**From:** Contact Centre (CRM) <contact@ribblevalley.gov.uk>  
**Sent:** 22 April 2024 12:59  
**To:** Planning  
**Subject:** Planning Application Comments - 3/2024/01/0196 FS-Case-607969058

**Planning Application Reference No.:** 3/2024/01/0196

**Address of Development:** Hawthorne Place

**Comments:** I wish to object to the application to the discharge of condition 9 (drainage plan) as ref 3/2024/0196 by Persimmon Homes Ltd.

Drawing Title
PLOT DRAINAGE

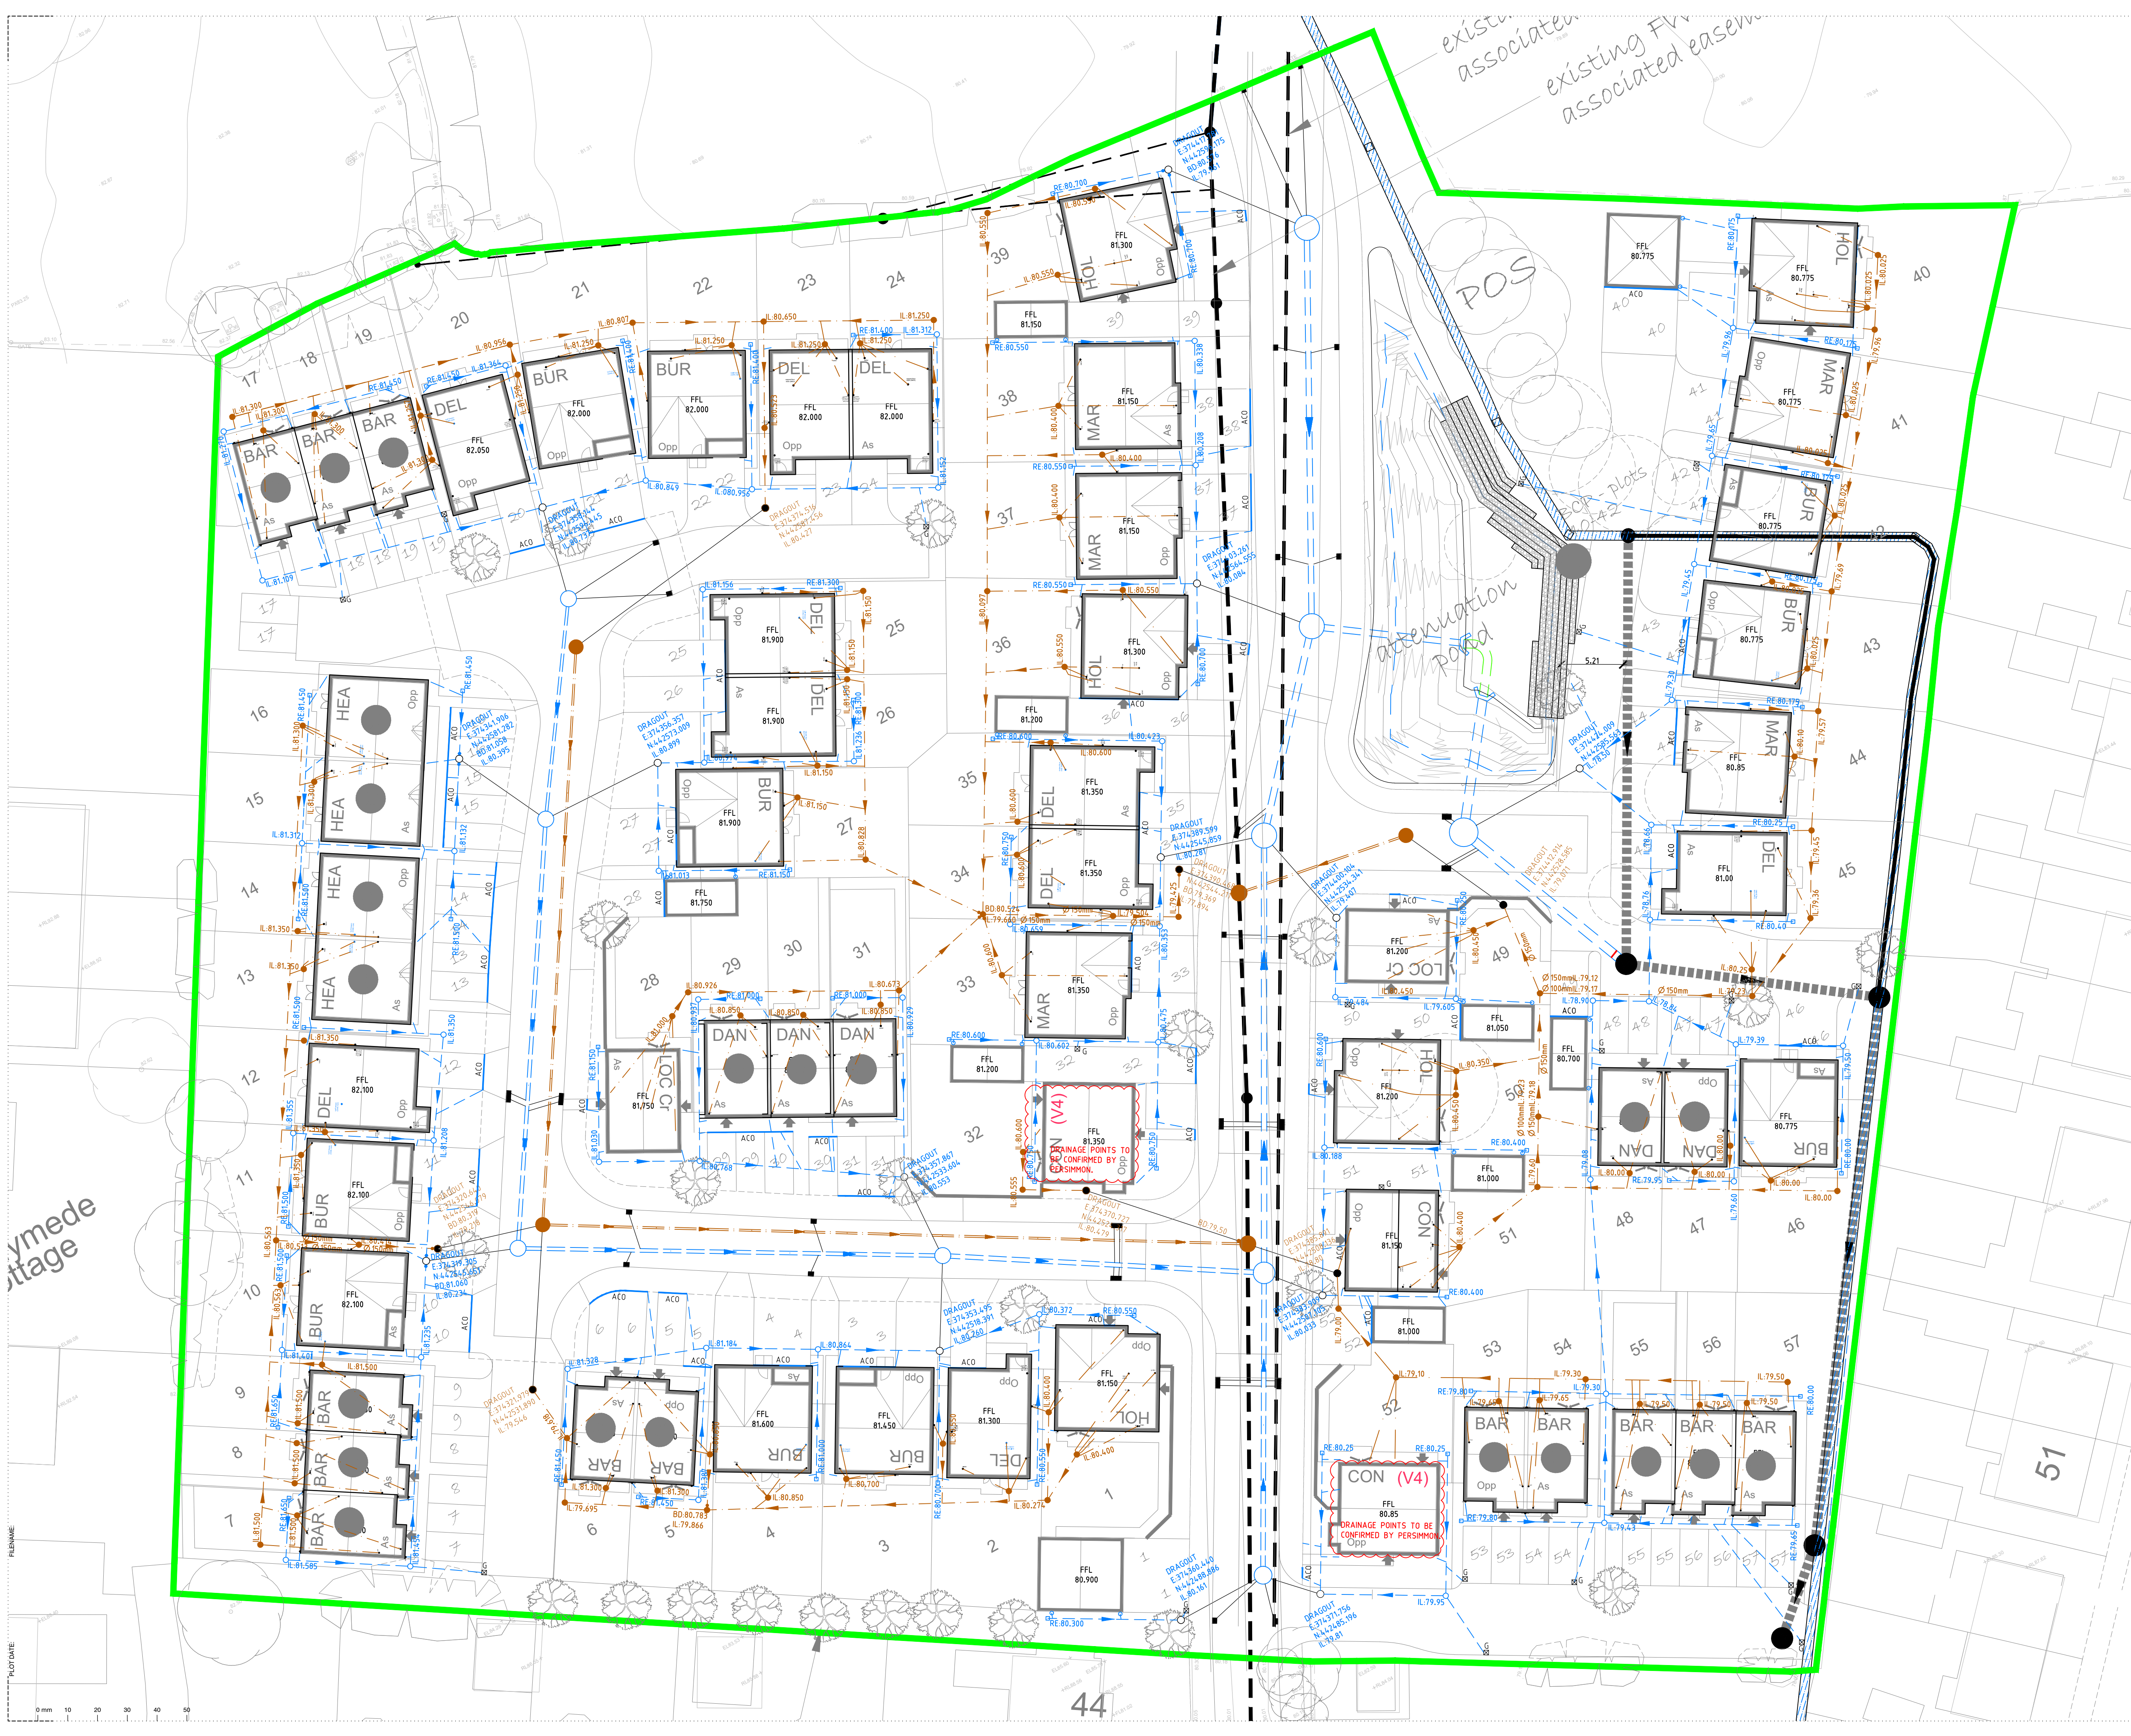
[REDACTED] to the buffer zone and still suffer flooding from the site [REDACTED] on a regular basis. This despite the installation of a French drain in the centre of the buffer zone. On the plans it shows the drain finishing in a soak away- this is not adequate, the drain should be connected to a main outlet as was stated by the site manager at the time. To compound this [REDACTED] on [REDACTED] and possibly more, are going to put land drains in their back gardens to join the main buffer drain. This would require testing to ensure it can drain water sufficiently to prevent flooding. We also note there is no cover on the surface and we already have clay soil covering the gravel. There is no mention as to who will manage this drain so this needs to be addressed by including it in the land management contract.

The drainage scheme involved raising the FFLs on plots 2 and 3 by approx 0.5m above the original land level and as much as 1.76m on other parts of the site. The result is the loss of privacy and an oppressive pervading presence of new houses and of course the flood issues. These issues could have been predicted before permission was given to build and the current plans do not in my view mitigate them
